From: Simon Davis
Sent: 05 February 2021 14:49
To: Planning Scanning
Subject: FW: P/97/20/PL- Land To North Of Summer Lane Pagham - error on plan?

From: Simon Davis
Sent: 05 February 2021 14:48
To: [REDACTED]
Subject: P/97/20/PL- Land To North Of Summer Lane Pagham - error on plan?

Just looking at the site plan and elevation drawings. Plots 96 & 97 on the site plan are labelled as having 4 beds but the only house type plans you have provided are all for 2 & 3 beds. I assume this is an error on the site plan and if so, can you change it and submit an amended plan to me with a new Rev number. I note that these houses are labelled as 4 beds on other submitted plans based on the layout but it is the proposed site plan that is most important to be altered.

Drawing Title
Proposed Site Plan
105 Unit Scheme

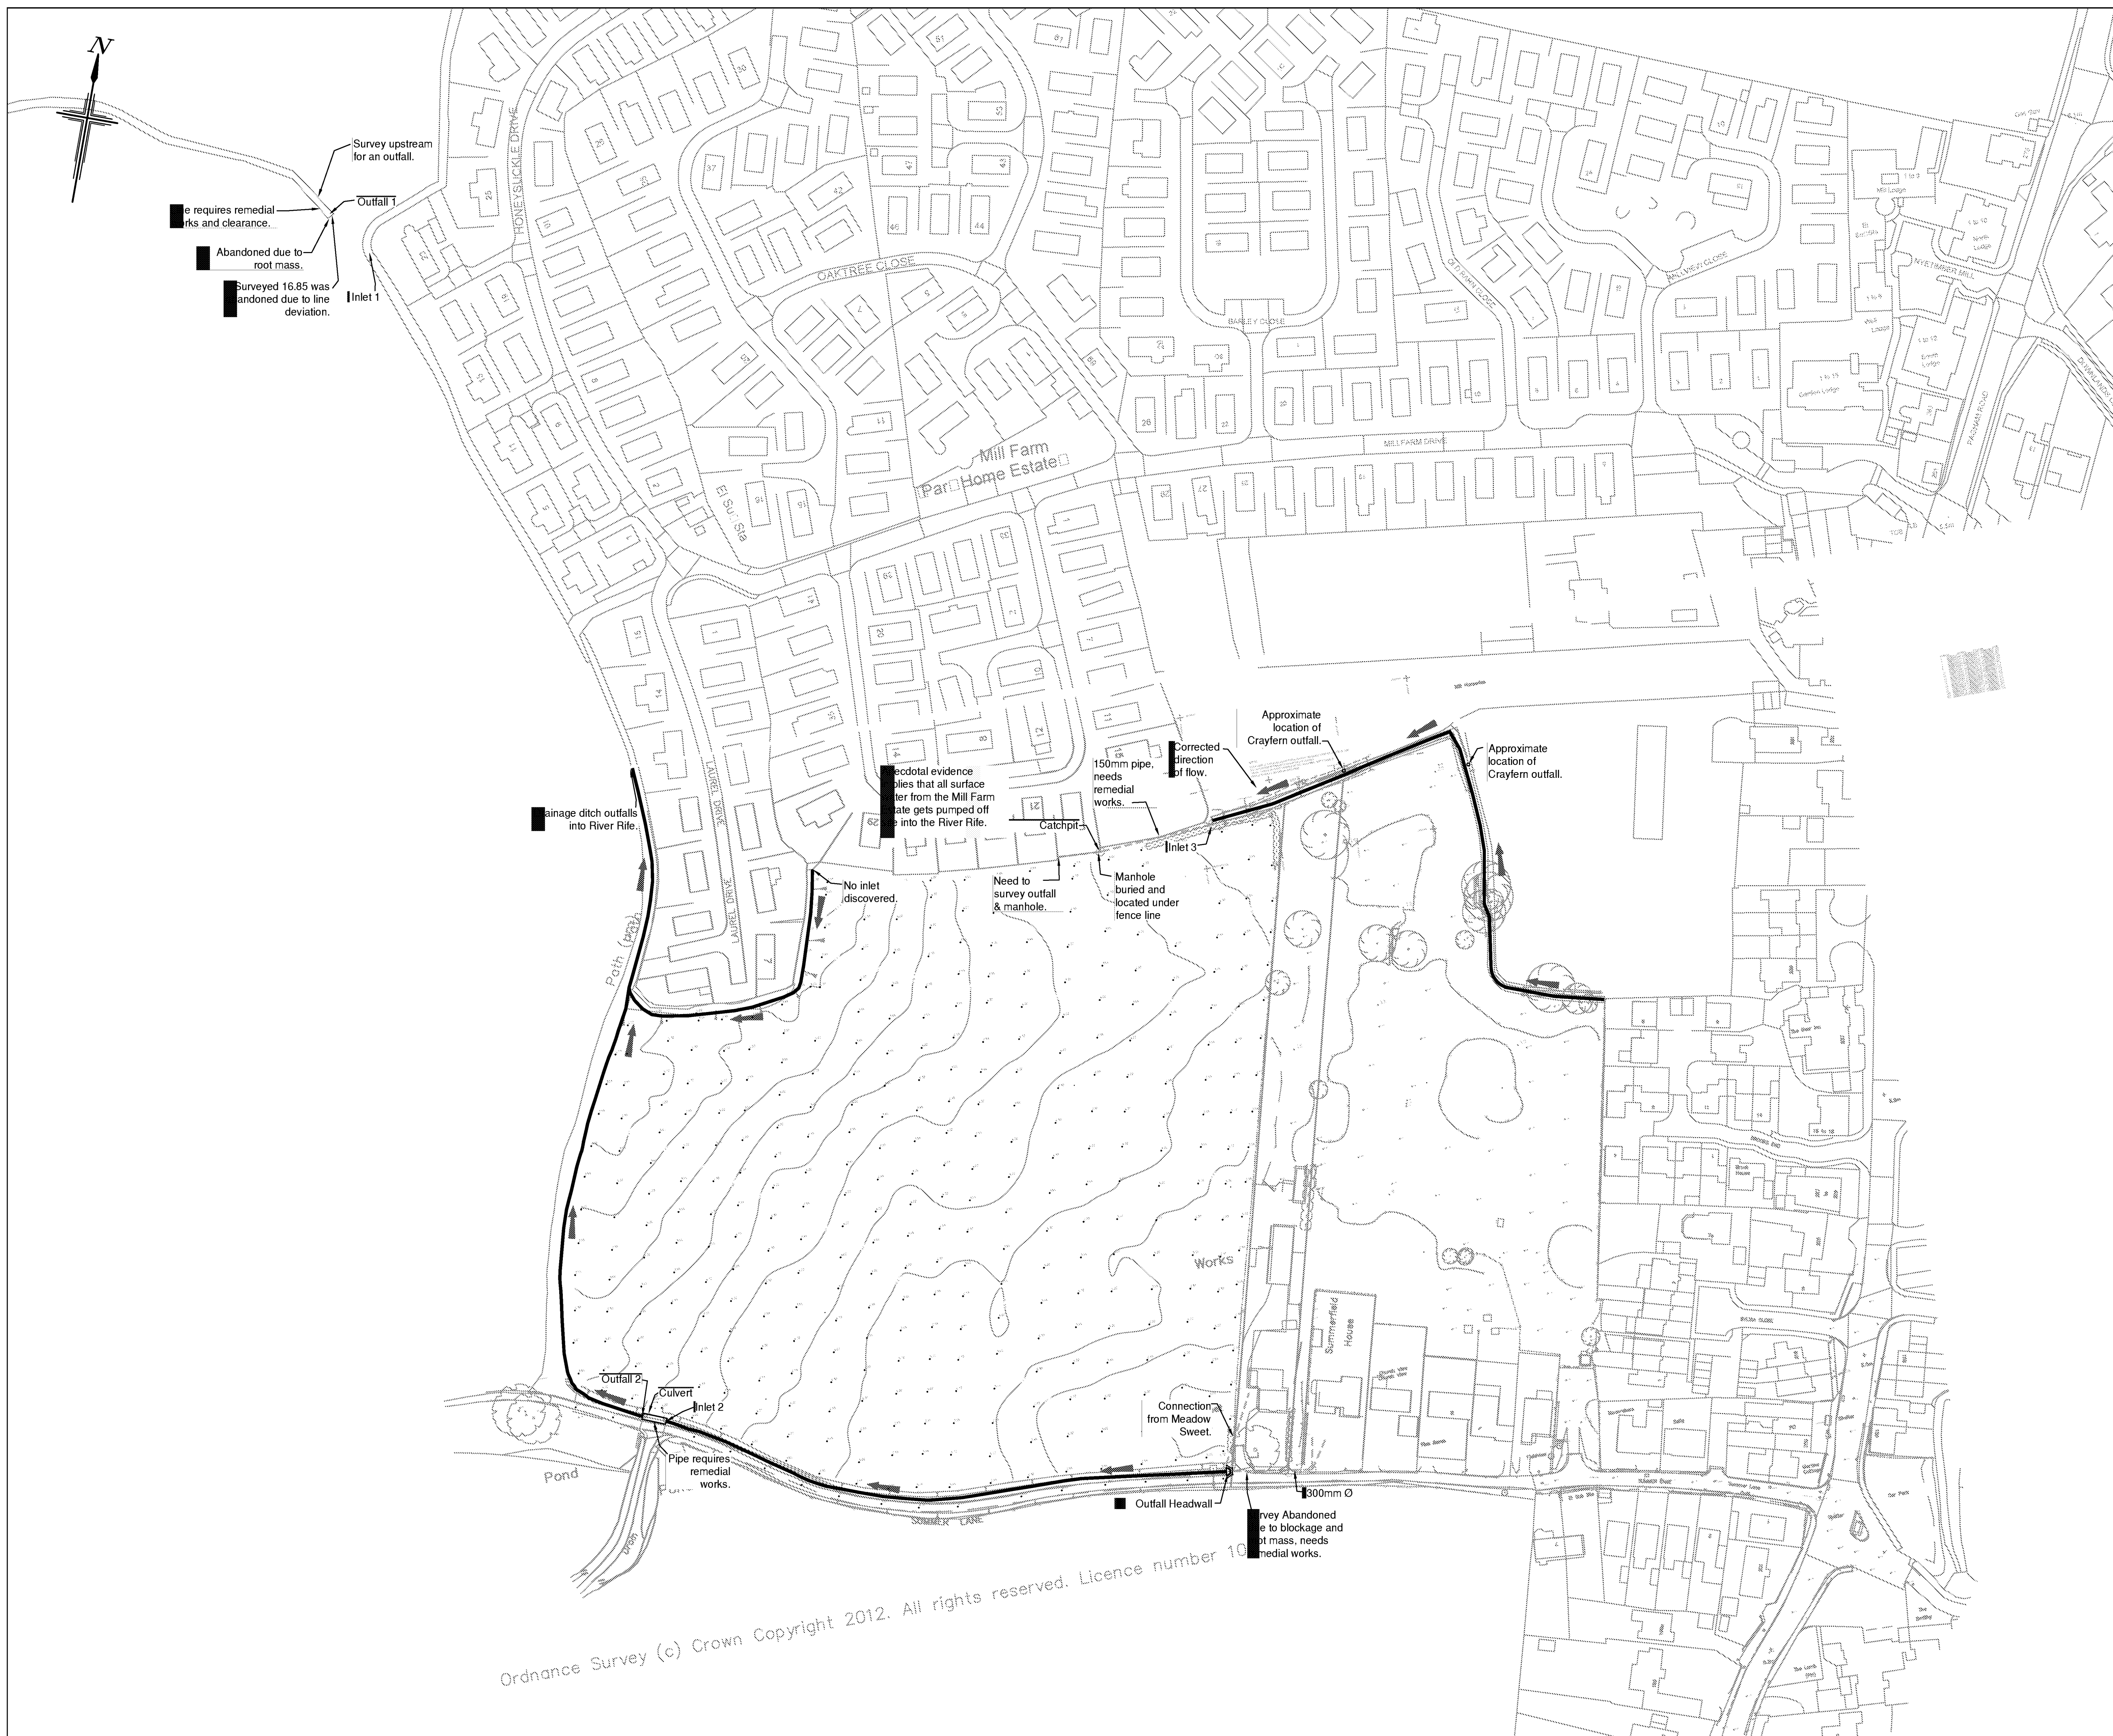
If it not an error then I will need the house type plans for these two units.
